Your ref: 3/2019/0336

**Planning Application No: 3/2019/0336;**  
**External Alterations to Building; Bowling Green Café, Castle Hill, Castle**  
**Grounds, Clitheroe, BB7 1BG. GT Ref: E19/0498.**

Elevations

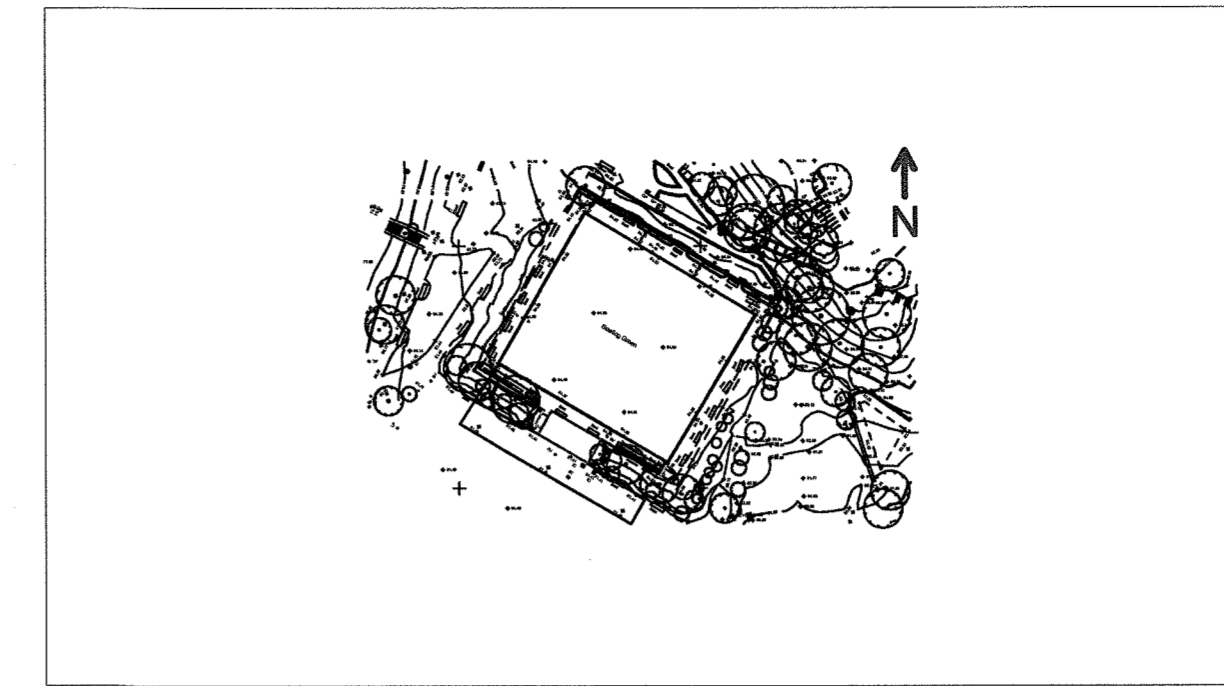
These repairs are welcomed in order to bring this Bowling Green Café back into use. We support the application. It is noted that ivy growth is advancing over the building and there appears to be no mention of any works to address this in the current works. We trust that this modest precautionary work could be incorporated into the current project.
